From: Katie Kurek [REDACTED]
Sent: 30 October 2017 13:44
To: Planning.Responses; Simon Davis
Cc: Derek Whittington
Subject: Planning Services Response Re-consultation EG/69/17

SUBJECT: EG/69/17/PL - 4 No. live/work units, Research & Development propagation building & growing area, garden room, fuel store & greenhouse to main dwelling & formation of new access. This application is a Departure from the Development Plan. More Information

Swallowfield, Eastergate Lane, Eastergate, West Sussex, PO20 3SJ

Heather Godmark			
Project: Swallowfield, Eastergate Lane			
Drawing Title: Visibility Splays and Swept Path Analysis			
Drawn By: Varles @ A2	Checked By: SMO	Approved By: ALB	PMR
Date: October 2017	Drawing No: 2016/3448/001	Rev: C

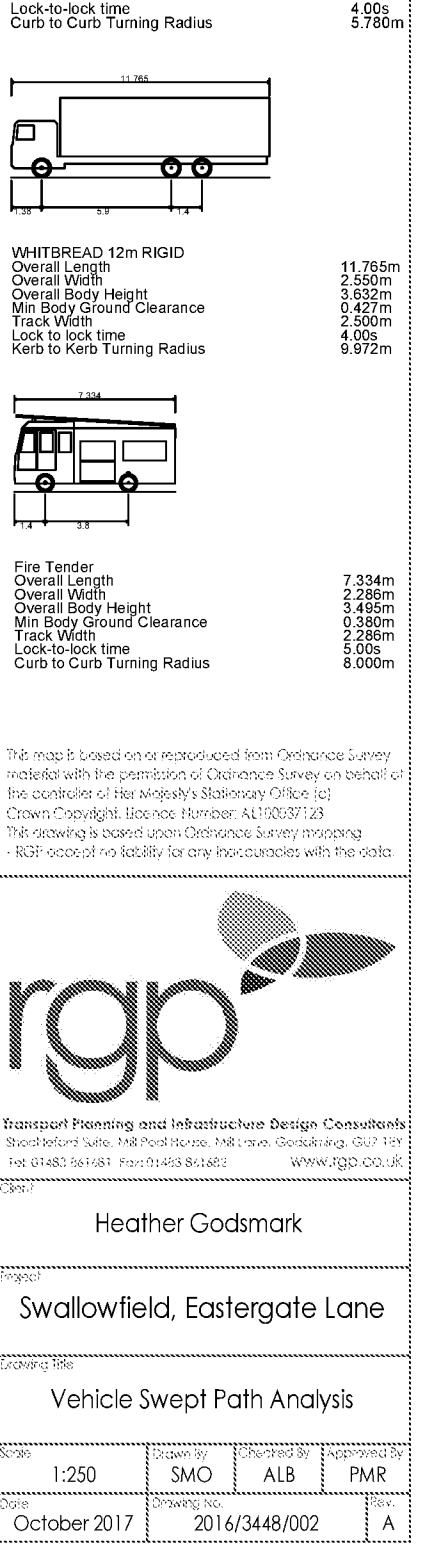
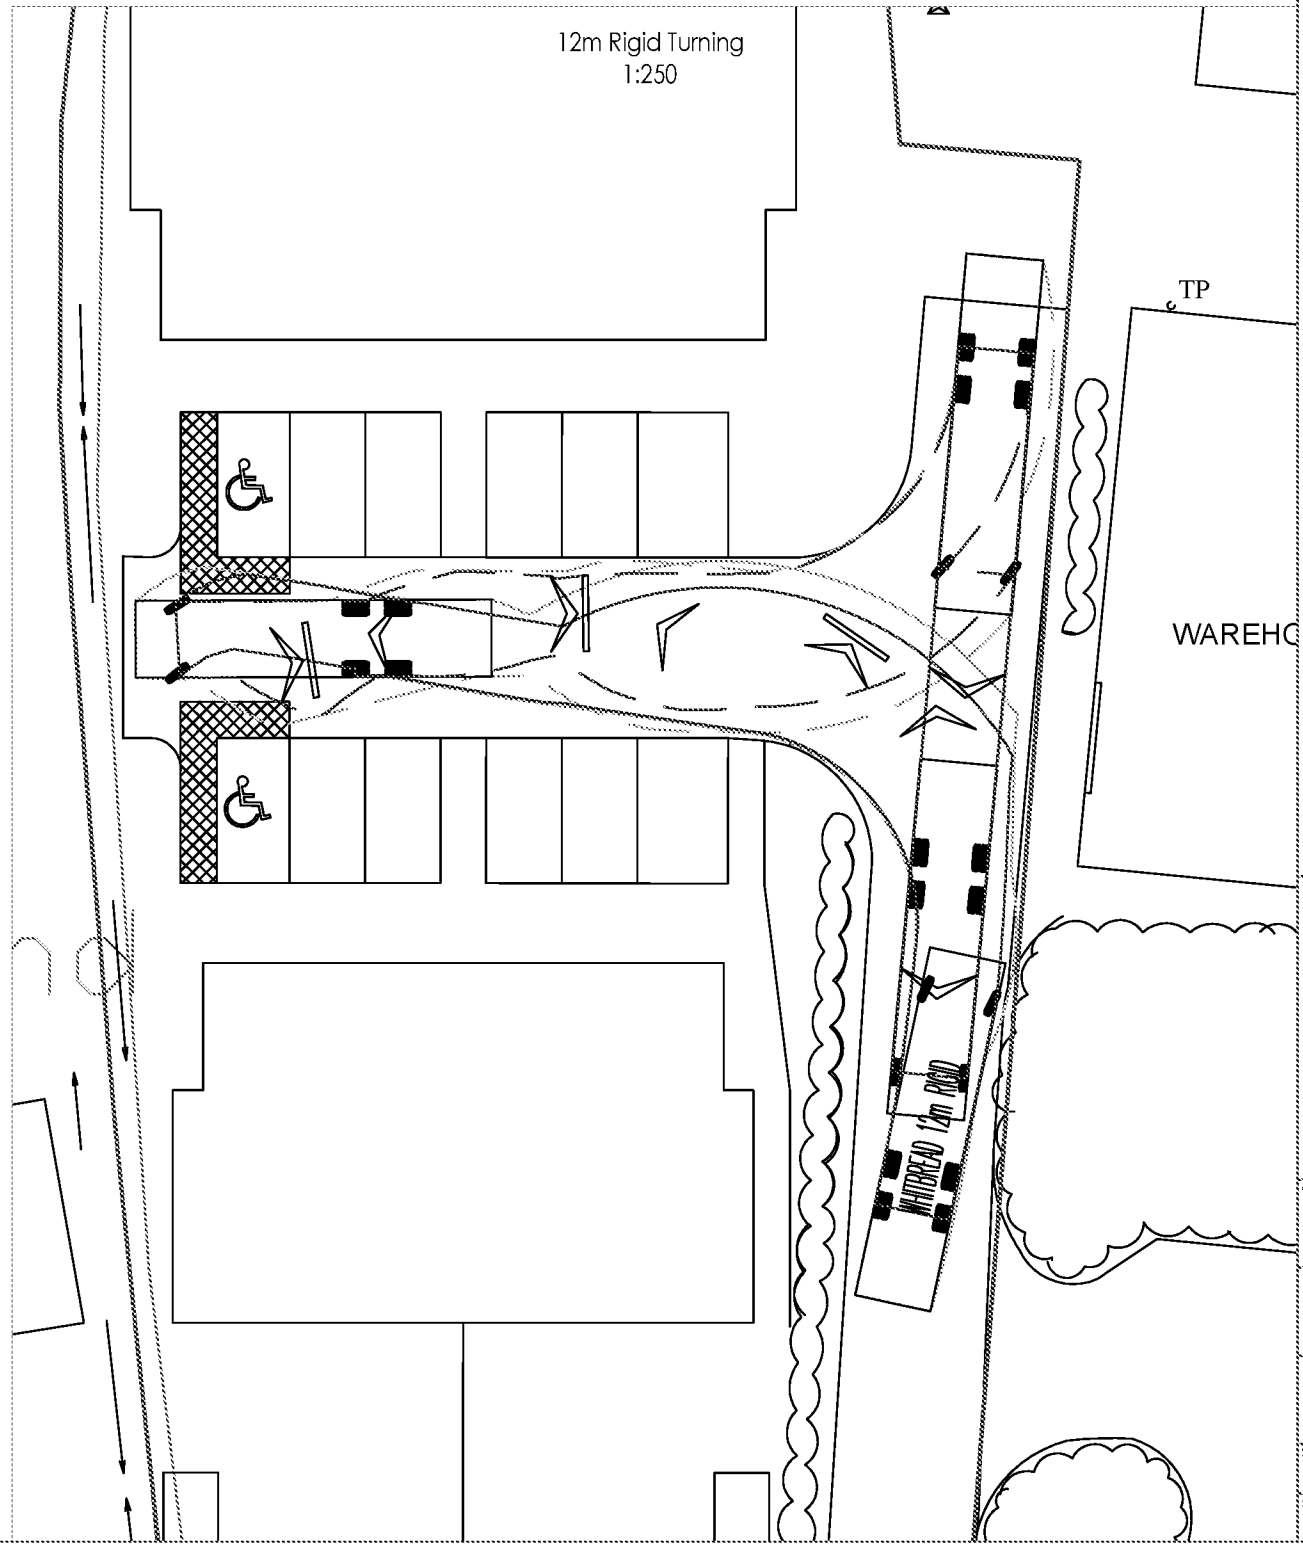
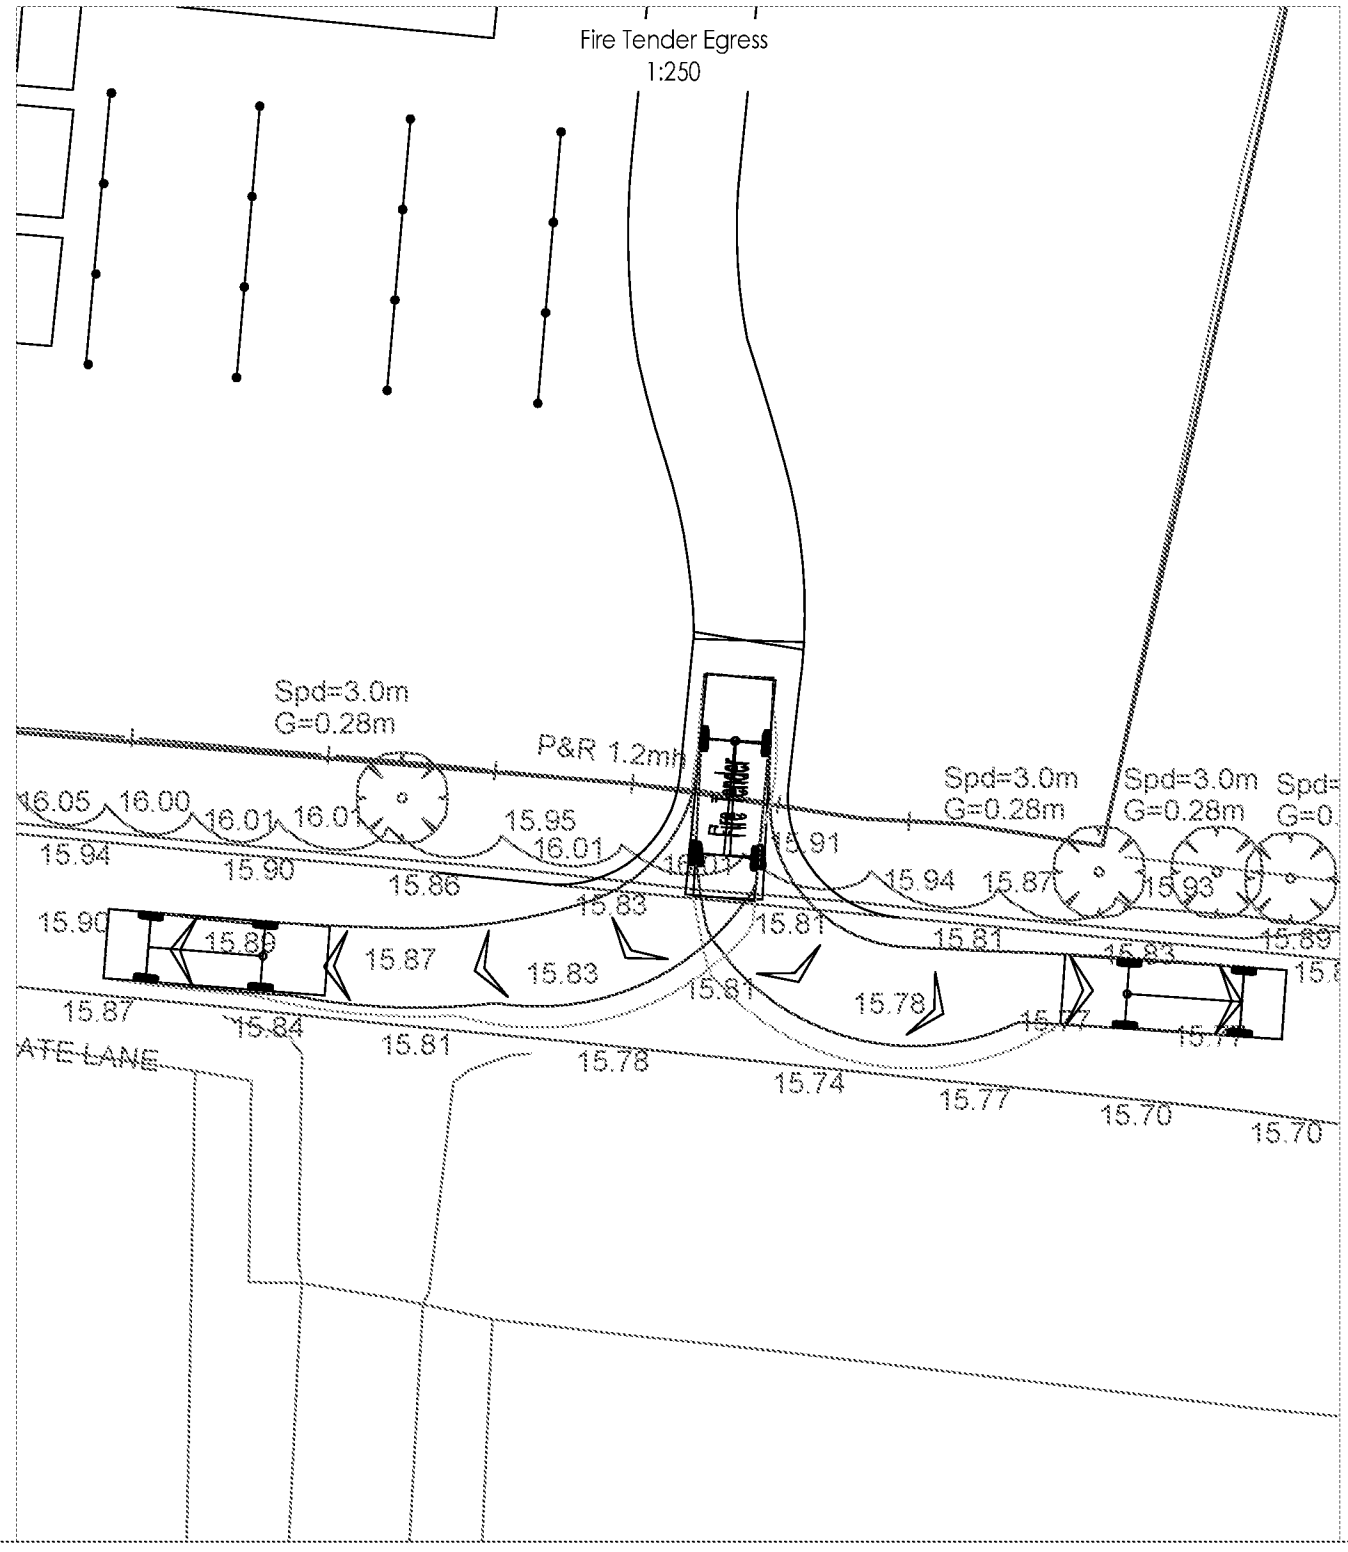
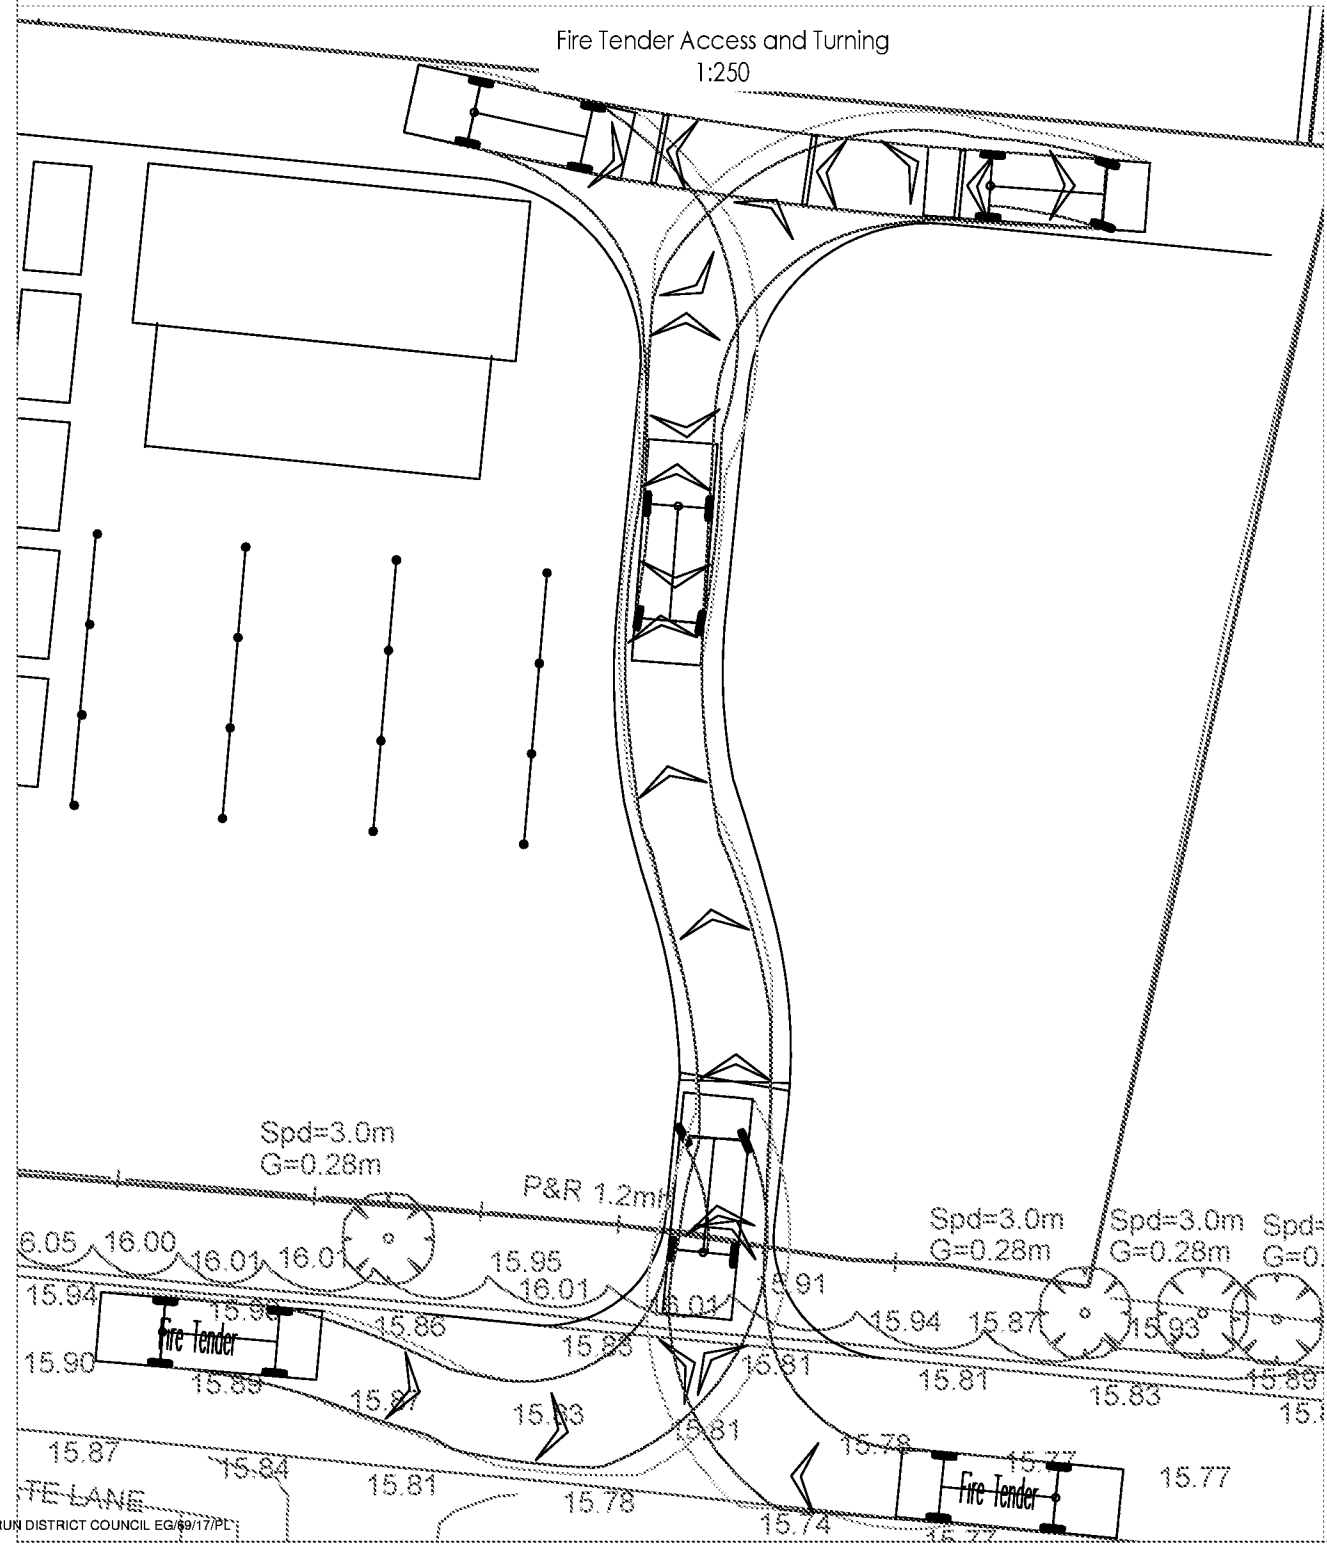
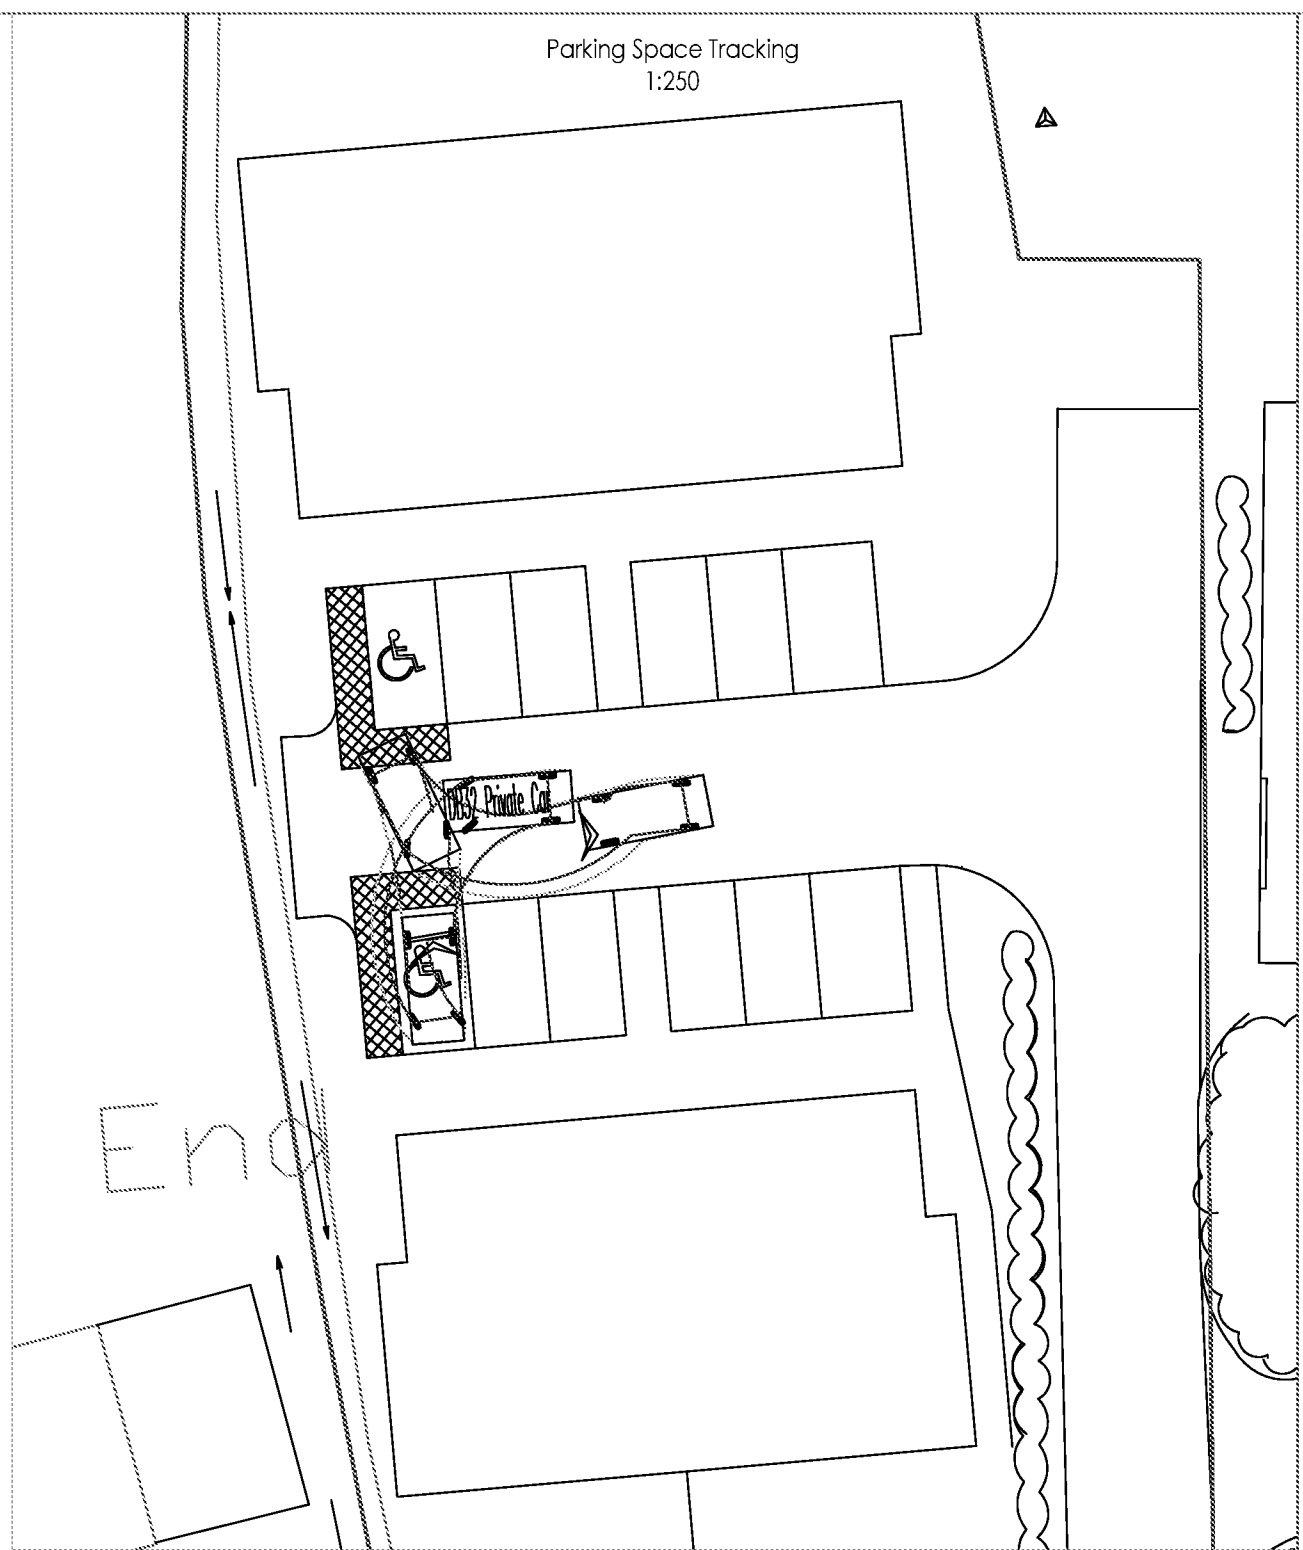
An updated Transport Statement (TS) has been provided along with RSA and Designers Response covering the proposed access works. One problem was identified in the RSA as outlined below:

Problem 3.1 - Risk of vehicle collision was identified as a result of vegetation on both sides of the access roads obscuring sight lines. The Designers Response concurs with the Auditors recommendation that vegetation is removed and regularly maintained to keep the splays in perpetuity.

The LHA are satisfied that the splays are achievable and maintainable with the removal of this vegetation though the Local Planning Authority (LPA) may wish to assess this from a street scene perspective.

Updated and additional swept path plans have been provided demonstrating that two cars can pass in each access and turn within both sites. It has also been demonstrated that larger vehicle (Refuse Collection and Fire Appliance) can access, manoeuvre within each site and egress in a forward gear. The LHA are therefore satisfied that safe and suitable access and appropriate internal layout has been demonstrated for these larger vehicles and that the turning facilities on site are satisfactory.

No part of the development shall be first occupied until visibility splays of 2.4 metres by 103 metres to the west and 2.4 metres by 106.8 metres to the east have been provided at both the existing and new site vehicular access onto Eastergate Lane in accordance with the approved planning drawings. Once provided the splays shall thereafter be maintained and kept free of all obstructions over a height of 0.6 metre above adjoining carriageway level or as otherwise agreed.
